Application for a non-material amendment following a grant of planning permission.

12 No. Social dwellings for Angmering Community Land Trust, including two communal bike stores, a pedestrian mews and orchard. Departure from the Development Plan.

| Reference number: | A/219/17/P |

Changes to certain materials/details , namely:-

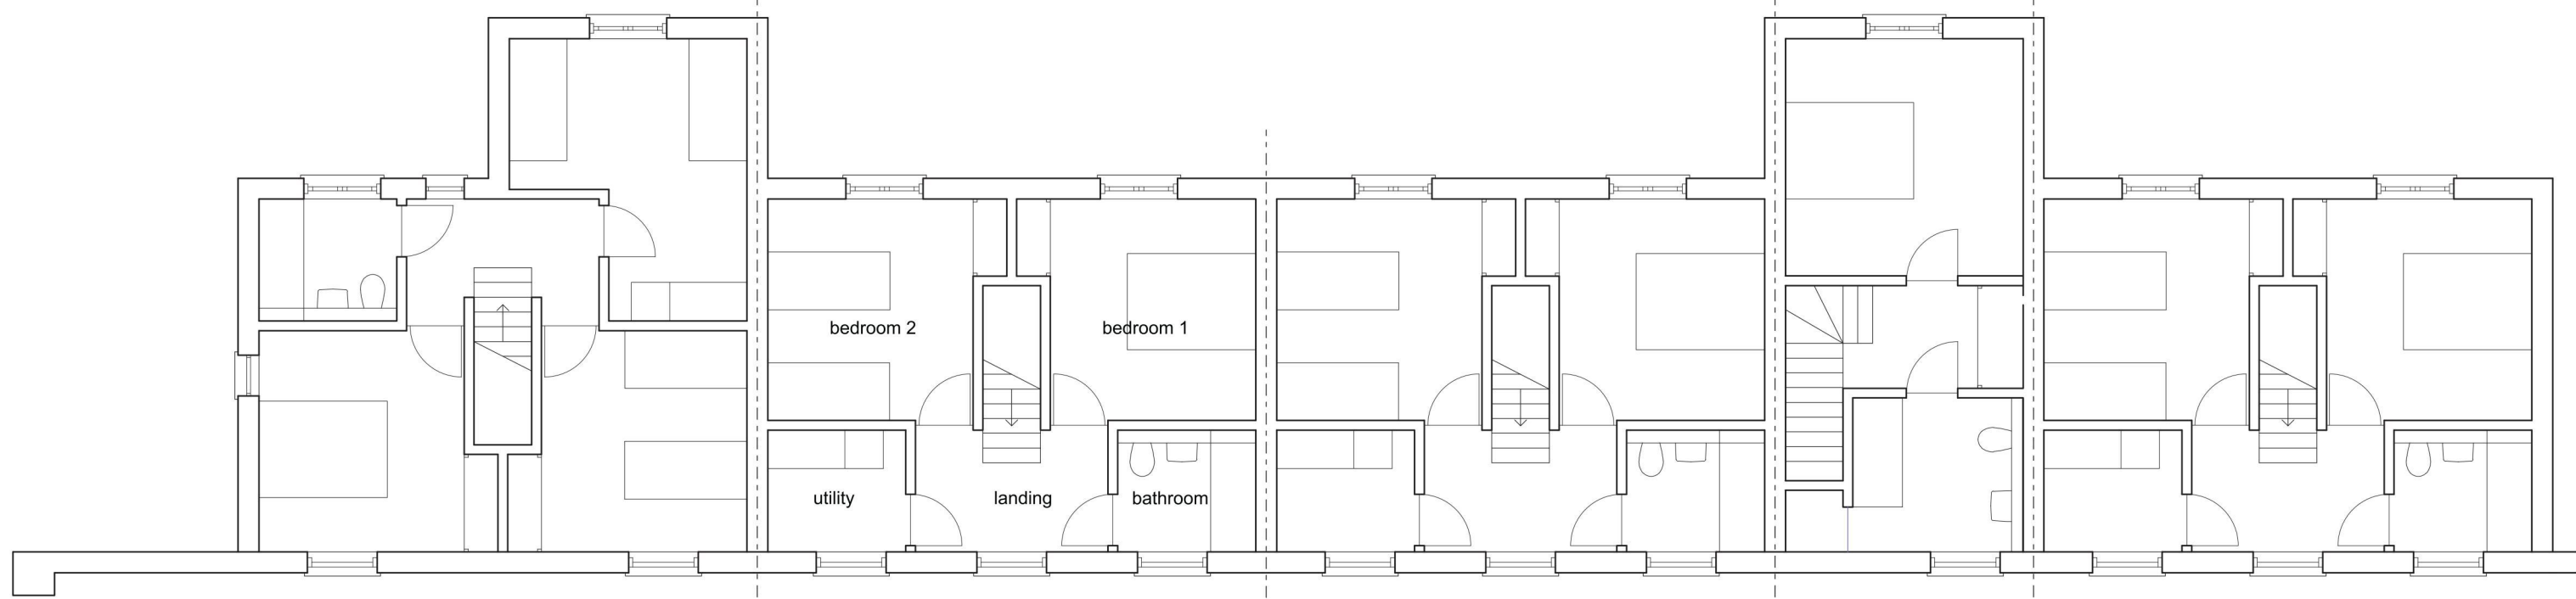
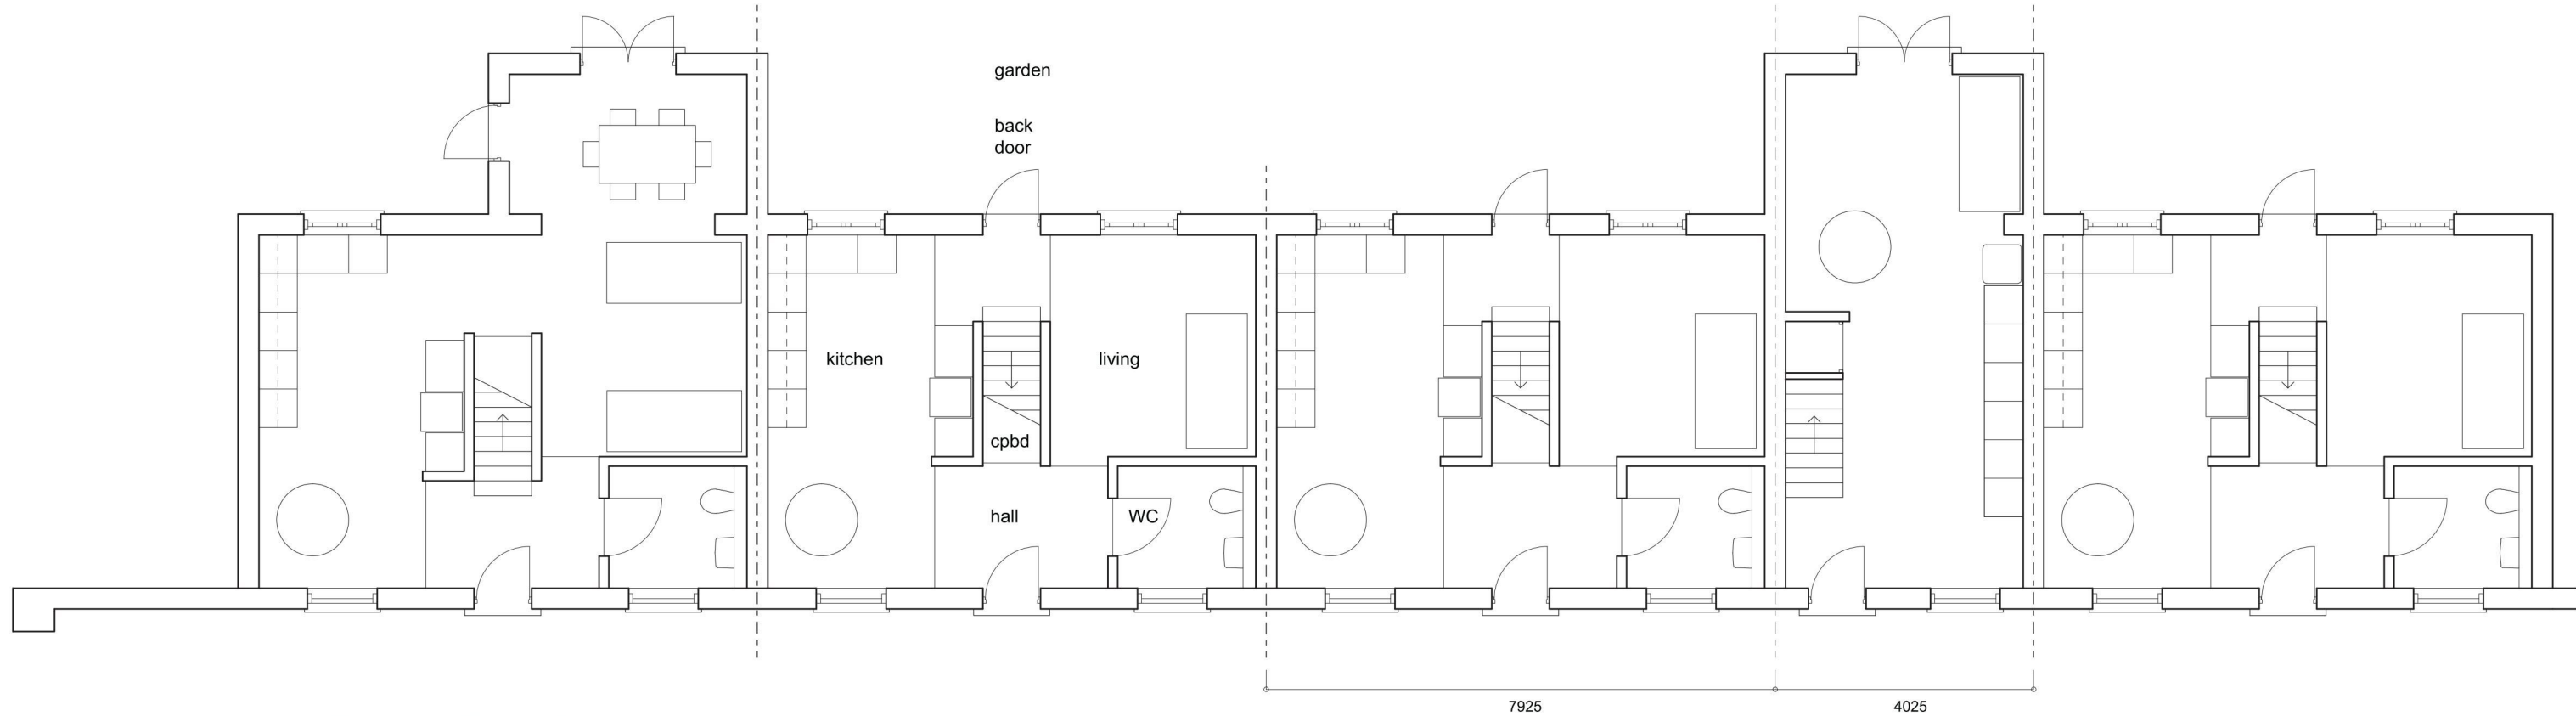
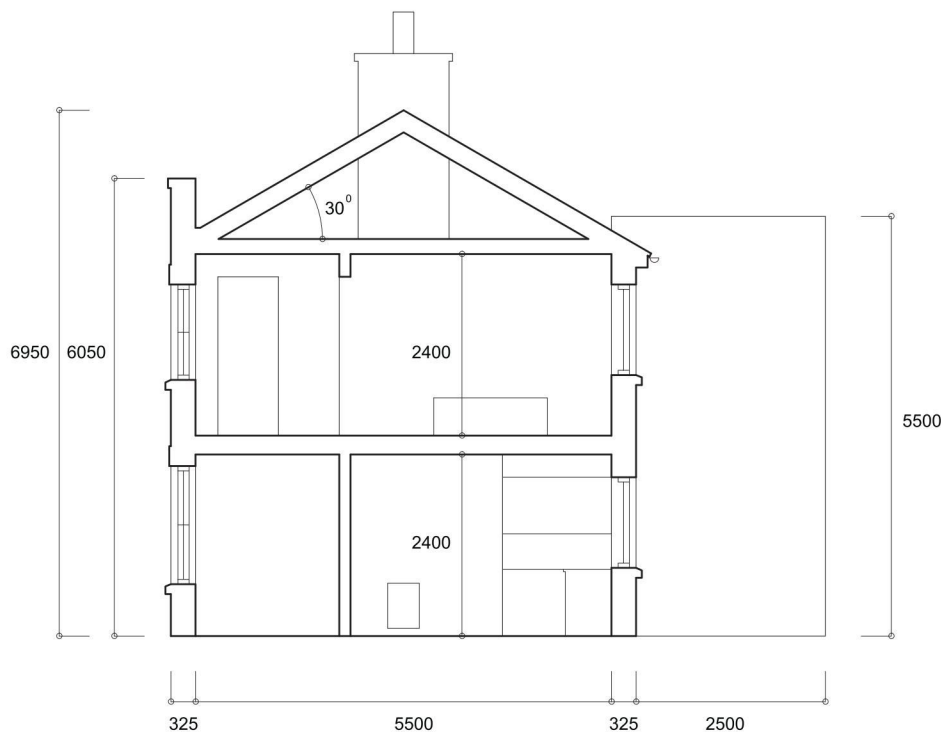
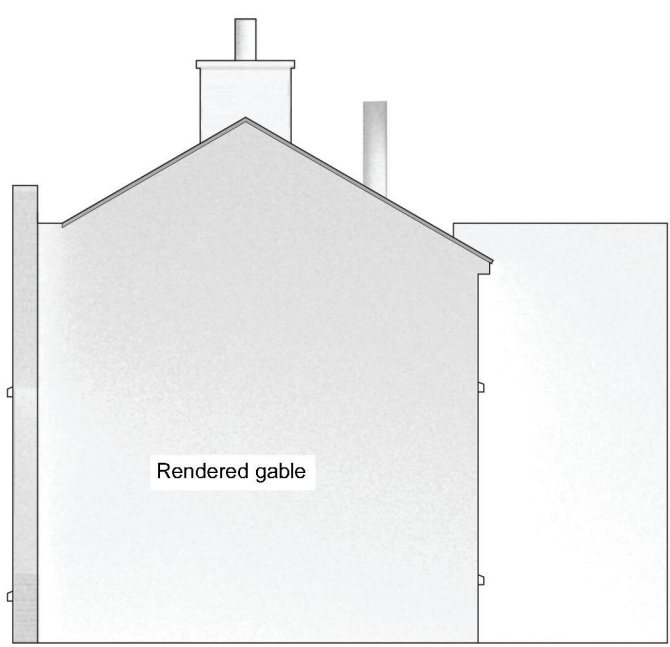
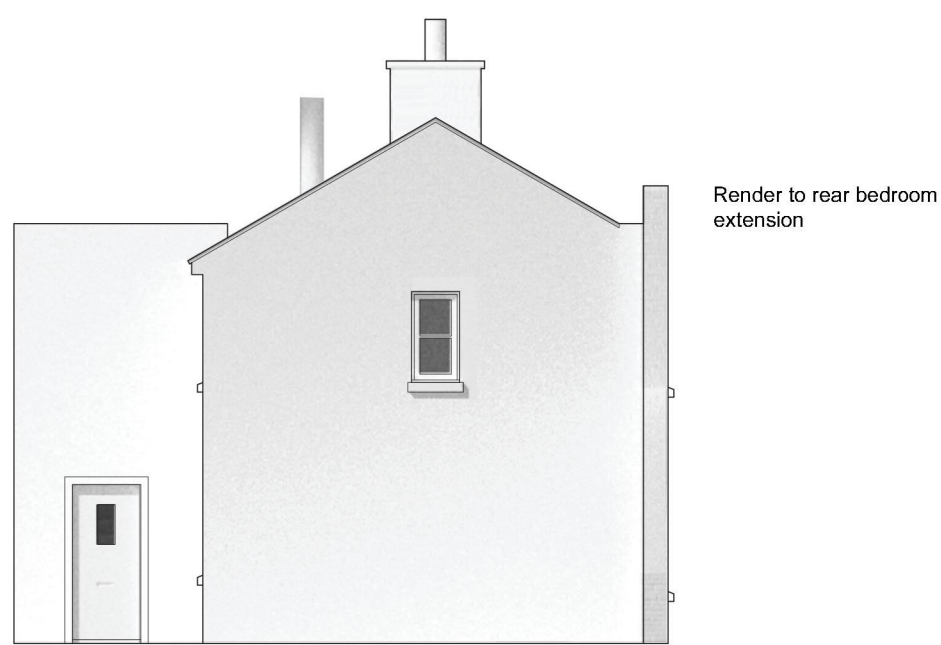
1There is no gas supply to this site and wood burners are environmentally damaging. Given these facts then the chimneys/flues will not be working items. It is proposed to remove the galvanised steel flues however all chimneys will remain but non-functional, with traditional masonry flues (pots). Reason: Environmental considerations  
2Roof tiles shown as clay pantiles will be changed to concrete pantiles while providing the same overall appearance. Reason: Development costs  
3Roof tiles to be artificial Slate providing the same overall appearance. Reason: This is clarification of what was only stated at planning as slate. Development costs would direct us to artificial.  
4Rainwater goods to be black PVCu with cast Iron effect. Reason: Development cost and on-going burden of cyclical maintenance.  
5Windows to be PVCu White providing the same overall appearance Reason: Development cost and on-going burden of cyclical maintenance.

6Front doors to be GRP composite PAS24 while providing the same overall appearance. Reason: Development cost and on-going burden of cyclical maintenance.  
7 - Lintol treatment amended where noted on drawings: RSJ detail changed in favour of homogenous brickwork, & window jointol treatment amended as noted
